WEST SUSSEX COUNTY COUNCIL CONSULTATION

TO:	Arun District Council FAO Ms M Tomalova
FROM:	WSCC - Highways Authority
DATE:	19 February 2020
LOCATION:	15-17 Kew Gardens, Bognor Regis, PO21 5RD
SUBJECT:	BR/27/20/DOC Approval of details reserved by condition imposed under ref BR/63/19/PL relating to Condition Nos 3 - dustbin storage, 5 - renewable energy, 7 - material & finishes, 10 - Construction Management Plan, 13 - cycle parking spaces, 15 - visibility splays and 16 - pedestrian visibility splays.
RECOMMENDATION:	More Information

Title:-
Proposed Site Plan (Bin & Cycle)

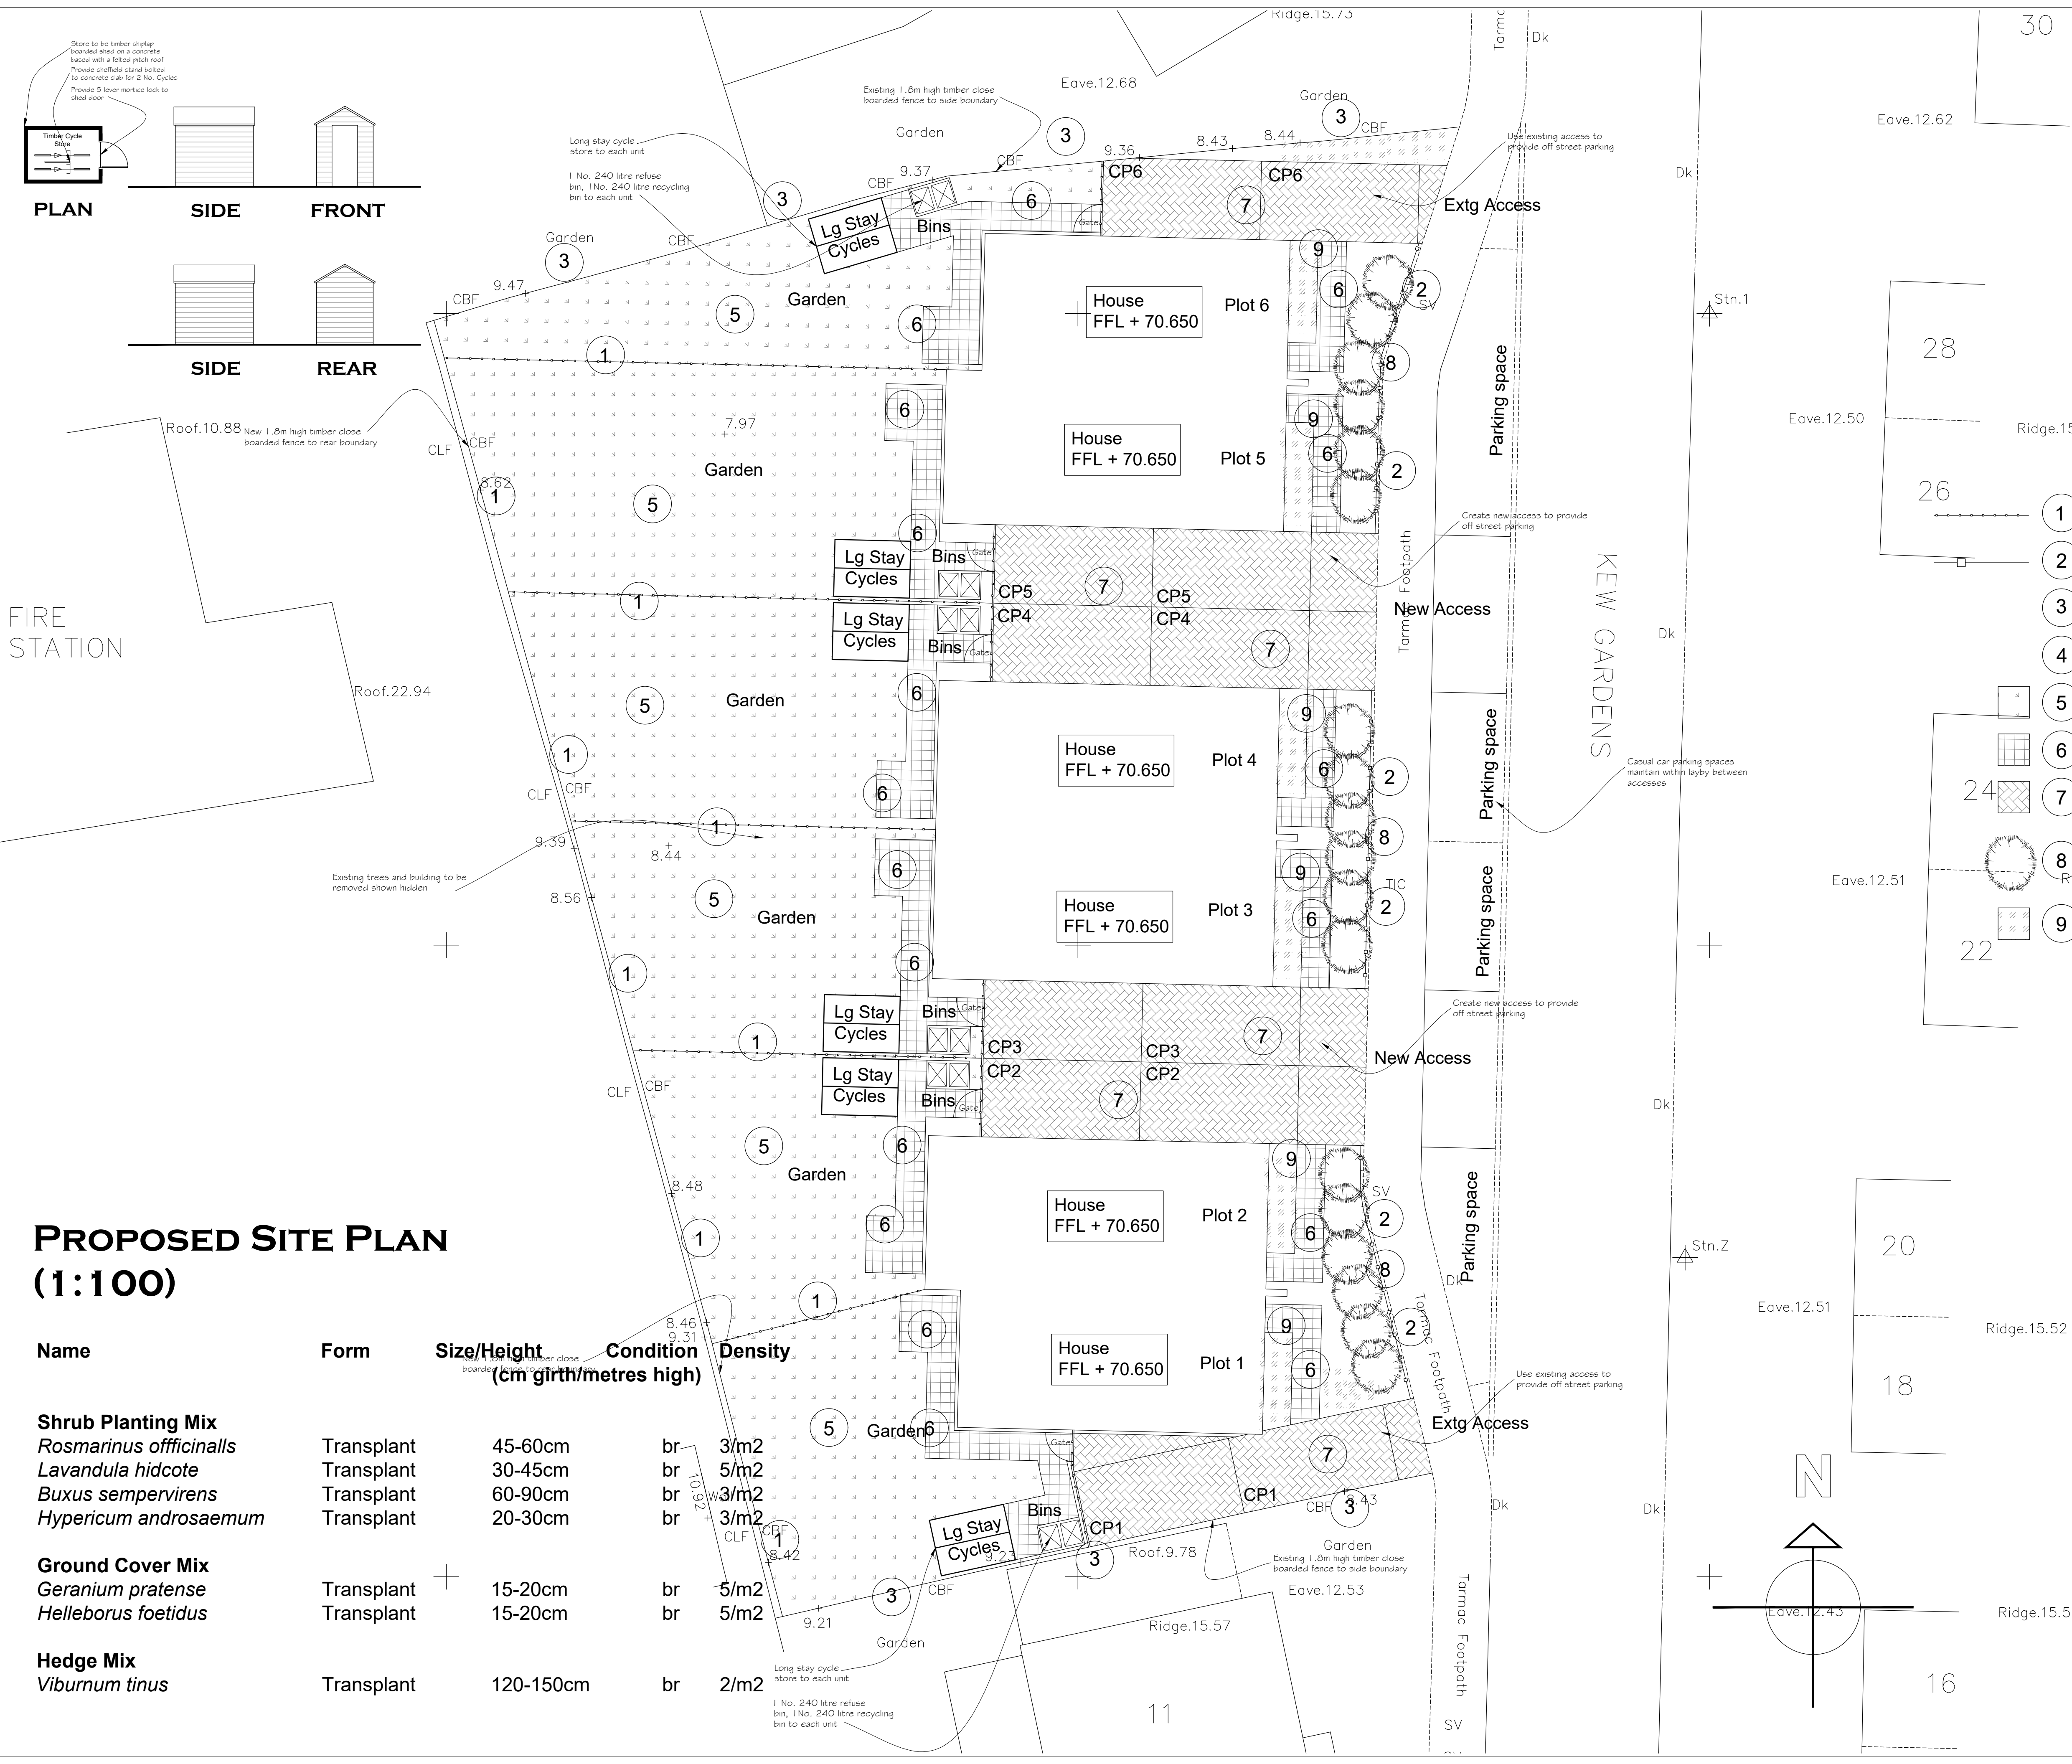
A secure and covered bicycle storage facility (shed) is indicated within rear of each plot. The plans and details pertaining to condition 13 are acceptable.

PROPOSED VISIBILITY SPLAYS
(1:100)

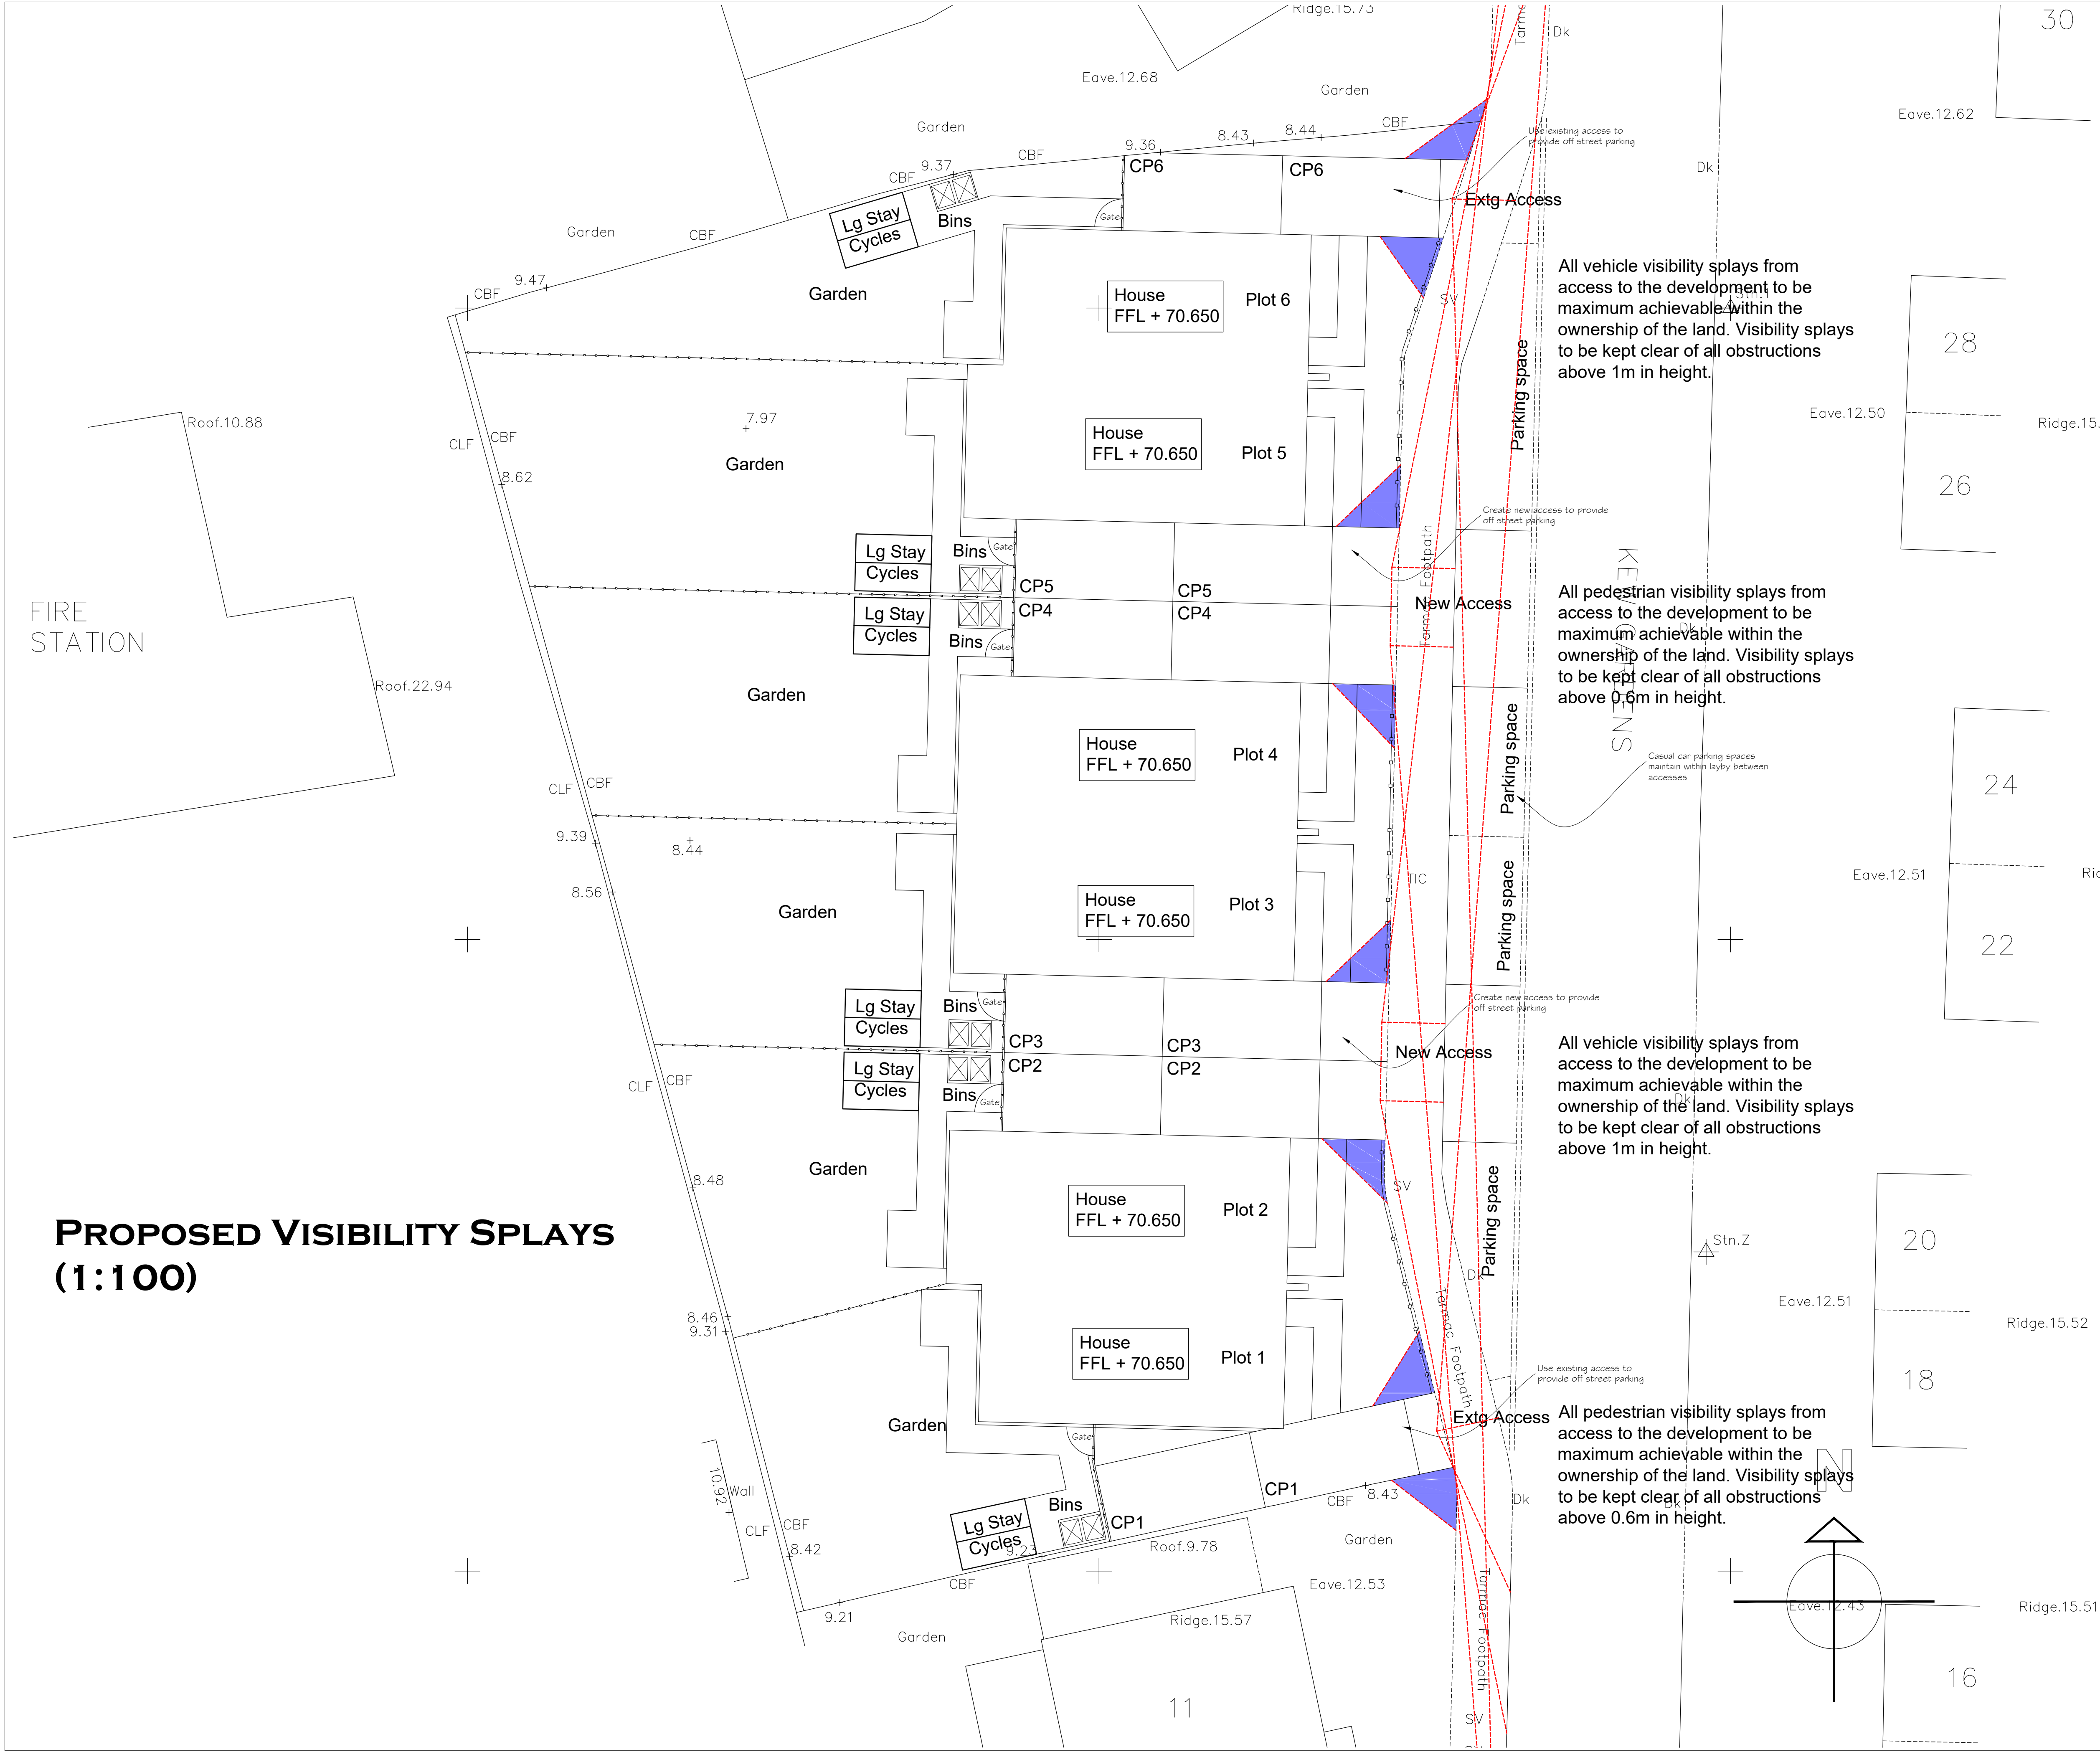
Maximum achievable vehicular visibility splays have been demonstrated from 2m back into each proposed access/car parking space. Considering the anticipated speeds and traffic levels, a 2m 'X' distance is accepted. The full extent of splays for each access point is not clear. The LHA acknowledge that the northern and southern most access points are existing however the splays for the new access points should be clearer with the full extent shown and splays achievable annotated.

The visibility splay plan indicates pedestrian visibility either side of each access. It is acknowledged that the furthest south and north splays are outside red edge of the site -

these should only be shown in land under applicants control. Please amend the plan accordingly.
